**WELWYN HATFIELD BOROUGH COUNCIL – DEVELOPMENT MANAGEMENT**  
**DELEGATED REPORT**

**APPLICATION No:** S6/2014/0781/FP

**SITE ADDRESS:** Northfield, Woodfield Lane

**DESCRIPTION OF DEVELOPMENT:** Retention of entrance gates, walls and railings

NUMBER **1305 / 02**

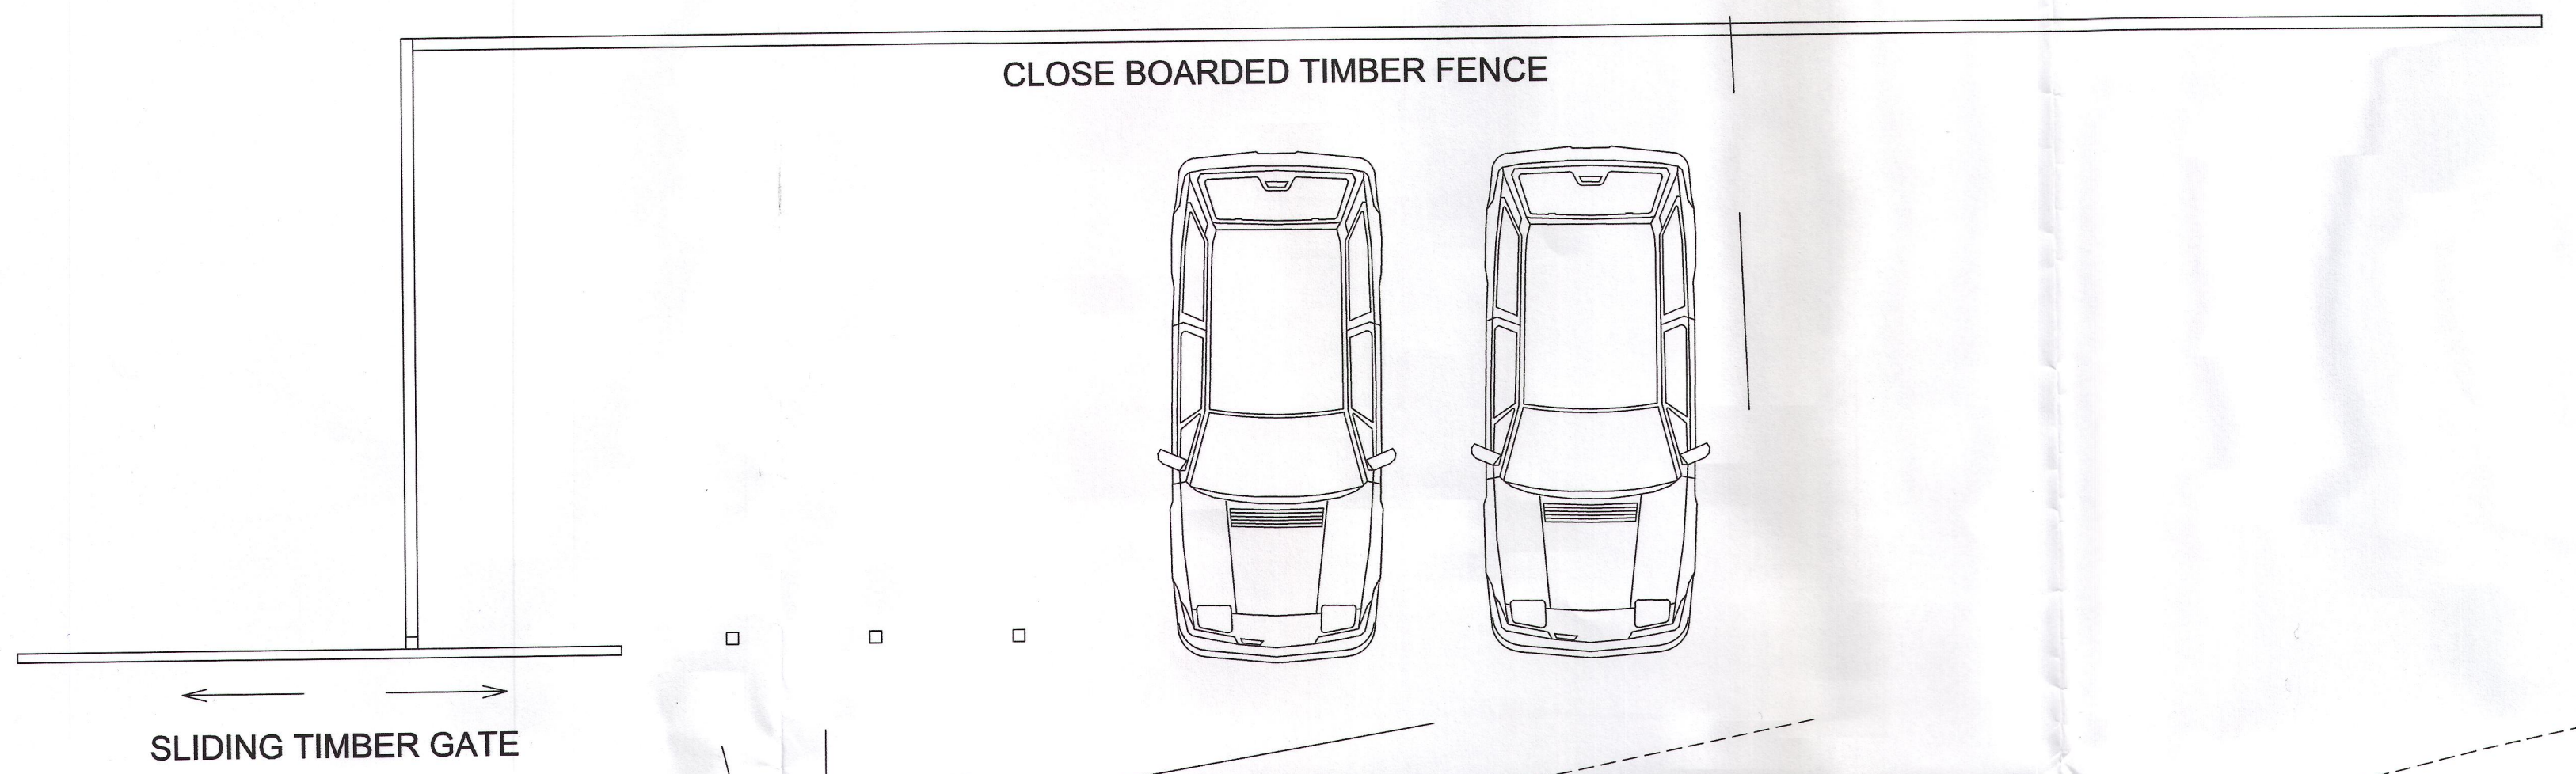
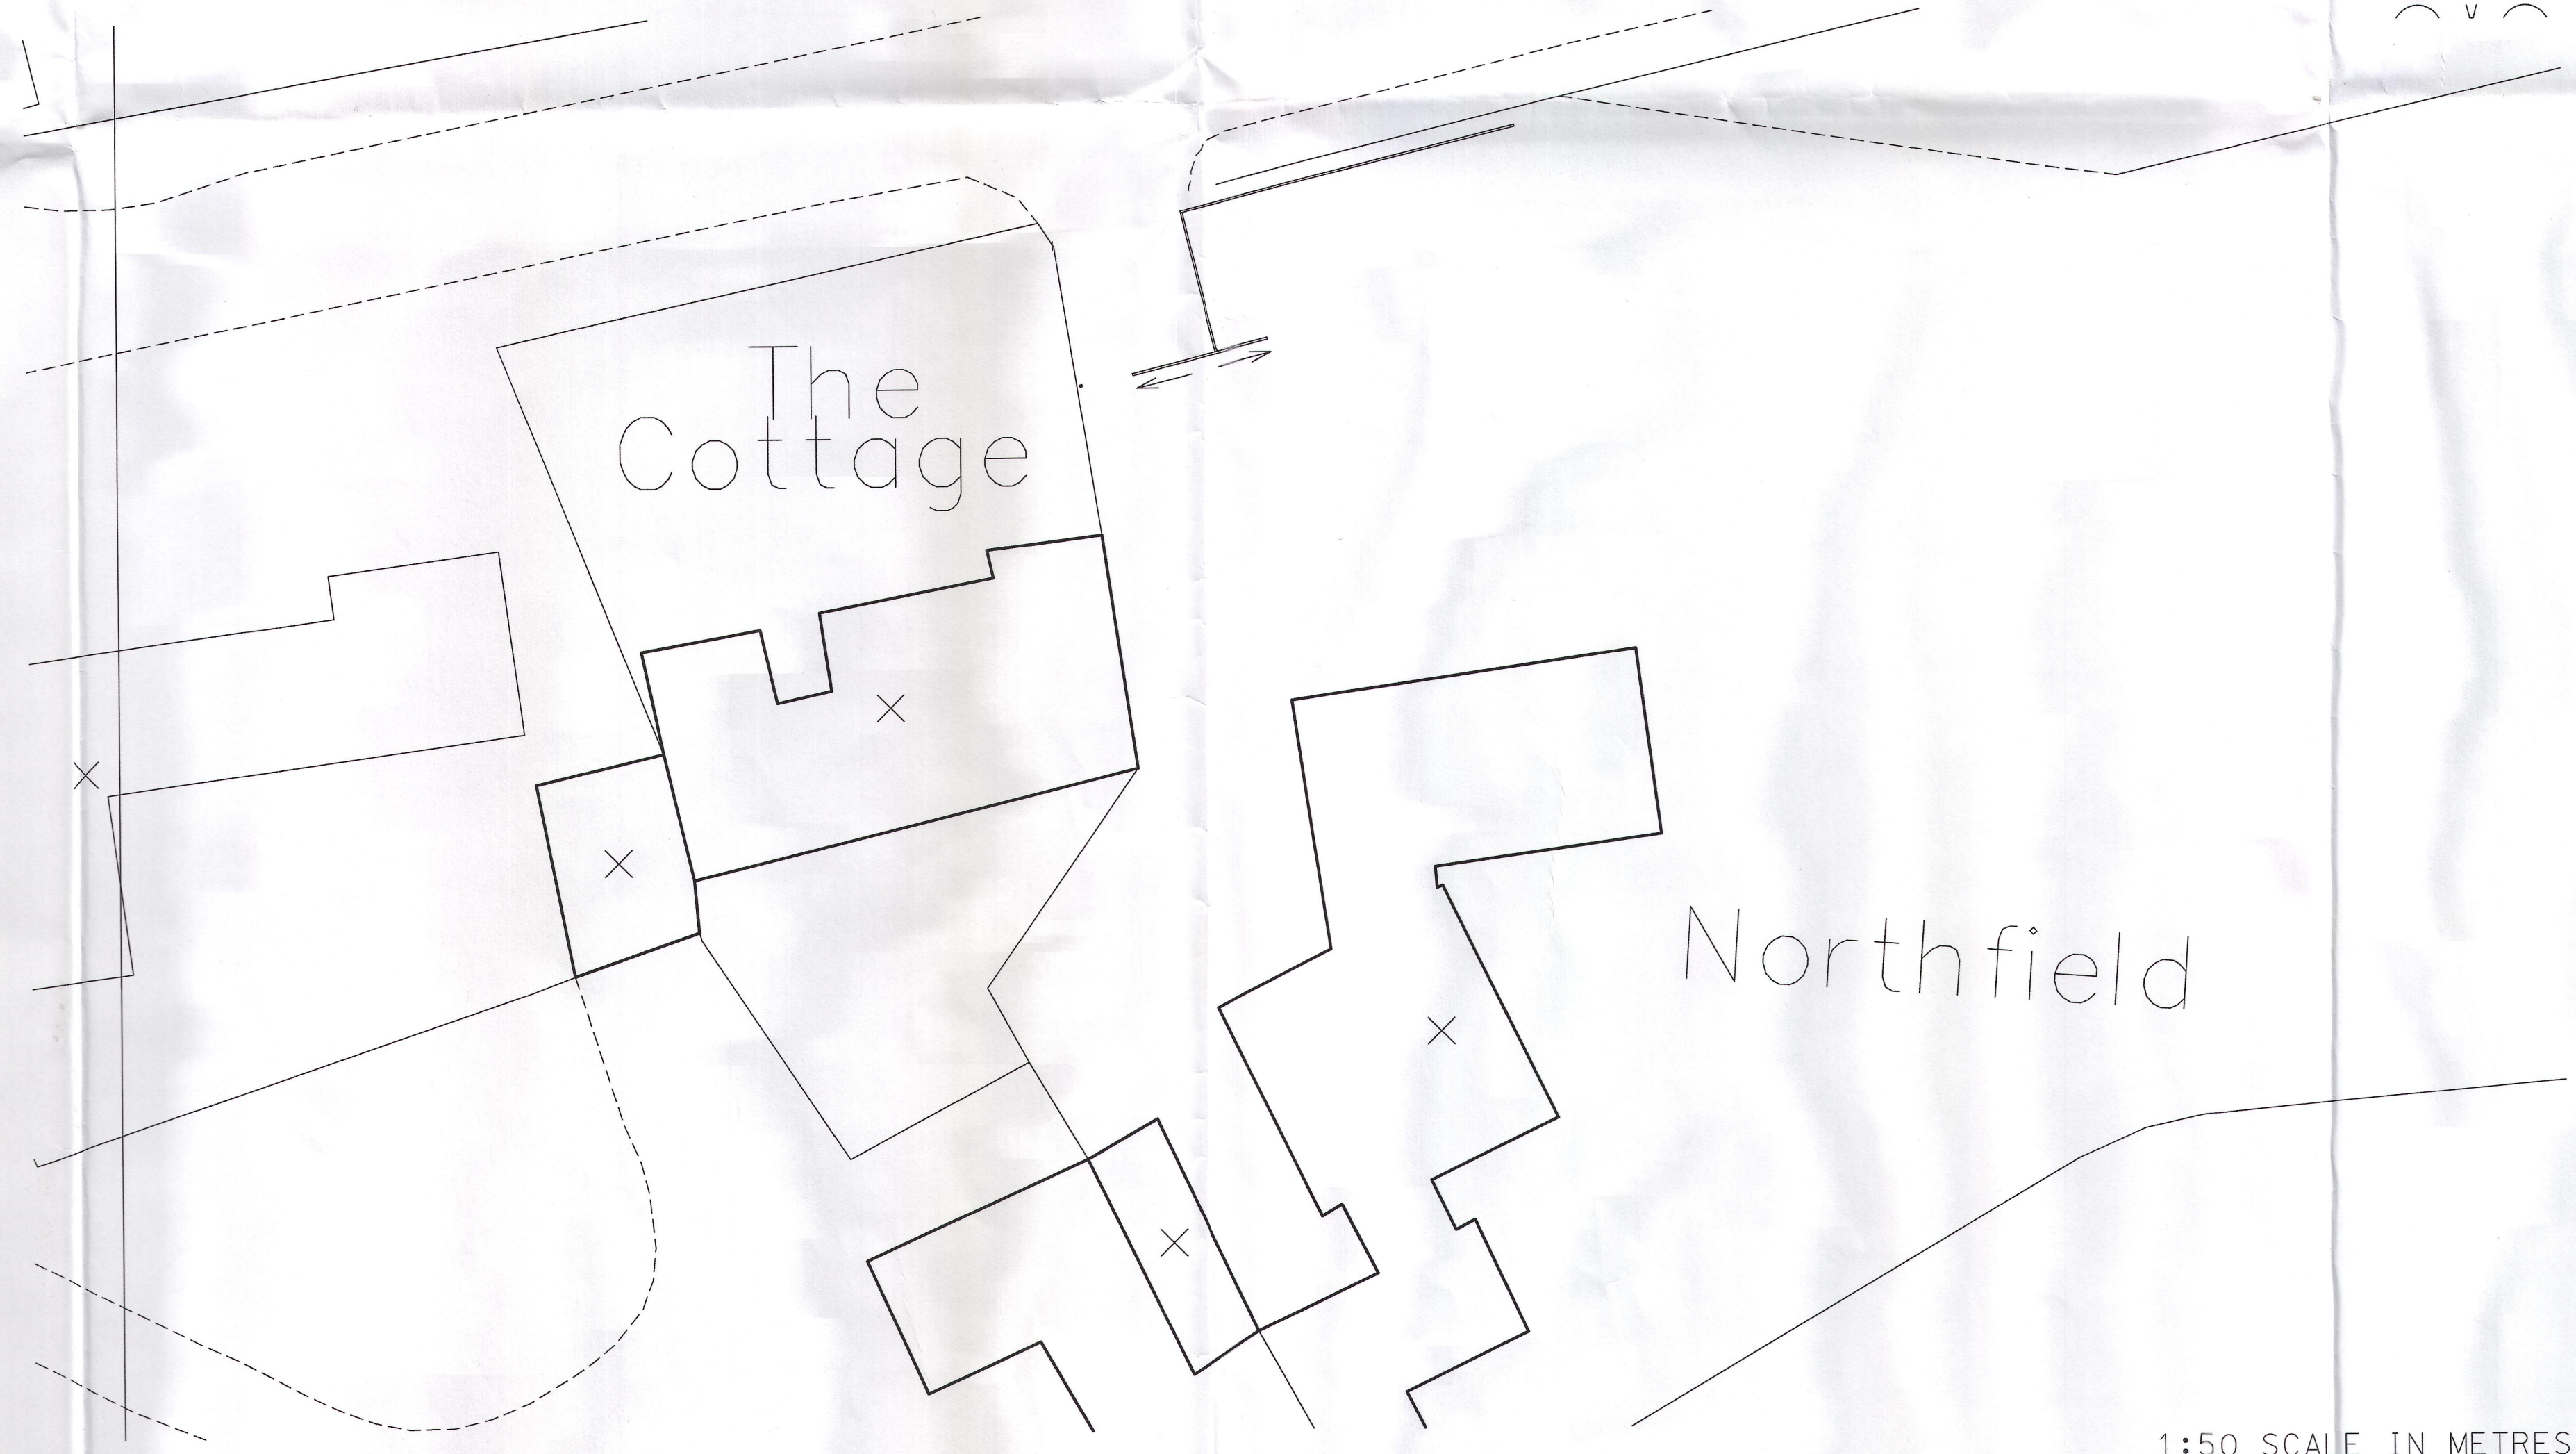
Paragraph 89 of the Framework states that the construction of new buildings in the Green Belt is inappropriate. By virtue of s.336 of the 1990 Act as amended, 'a building' includes any structure or erection, therefore, the proposed wall, pillars, railings and gates constitute a building for planning purposes. Because the development is not listed as an exception in paragraph 89 of the NPPF, the wall, pillars, railings and gates are inappropriate development. As such, the development is, by definition, harmful to the Green Belt and conflicts with the NPPF, to which substantial weight is attached.

The wall, pillars, railings and gates are a surprising development when set against the rural surrounds. They draw the eye and appear as an incongruous addition to the locality forming a visually intrusive feature. The development also harms the semi-rural character and appearance of the area, contrary to Policy RA10 of the Welwyn Hatfield District Plan which expects developments in rural areas to, amongst other things, contribute to the local landscape character. Also, it would be at conflict with Policies D1 and D2 which seek high standards of design and that developments respect the character and context of the local area, and it would not satisfy the design principles set out in the Supplementary Design Guidance of the Welwyn Hatfield District Plan 2005.

In addition, Paragraph 80 of the NPPF sets out the five purposes of including land in the Green Belt. These include safeguarding the countryside from encroachment. Whilst the development would be within the residential curtilage of the property, the property is set back from the road by approximately 20m and garden land and a driveway are to the front of the dwelling. The wall, pillars, railings and gates have increased the built urban form within the area close to the site frontage resulting in significant encroachment of development into the countryside conflicting with the purposes of including land within the Green Belt. This view is reflected within a recent appeal ref: APP/C1950/D/13/2190944 for 63 The Ridgeway, in which the Inspector found that although a wall was within the curtilage of the dwellinghouse, the development still resulted in encroachment due to the increased built urban form, and this approach taken is agreed with.

Woodfield Lane is an un-numbered classified C road designated as a local distributor road. The speed is unrestricted. Although the gates are only set back approximately 4.575m into the site, the grass verge means that they are set back almost 6m from the edge of the carriageway which is sufficient to enable a vehicle to wait clear of the carriageway whilst the gate opens. The proposal is considered unlikely to result in an inconvenience to highway users or impact significantly on highway safety.

1. The proposal is inappropriate development in the Green Belt by definition. Due to its siting, design and scale, the proposal fails to assist in safeguarding the countryside from encroachment, has caused substantial harm to the openness of the area and is detrimental to the visual amenities of the Green Belt. There are no very special circumstances that would outweigh the harm caused to the Green Belt. Therefore, the development would be contrary to The National Planning Policy Framework and the Policies GBSP1, RA10, D1 and D2 of the Welwyn Hatfield District Plan 2005 and the Supplementary Design Guidance, Statement of Council Policy 2005.
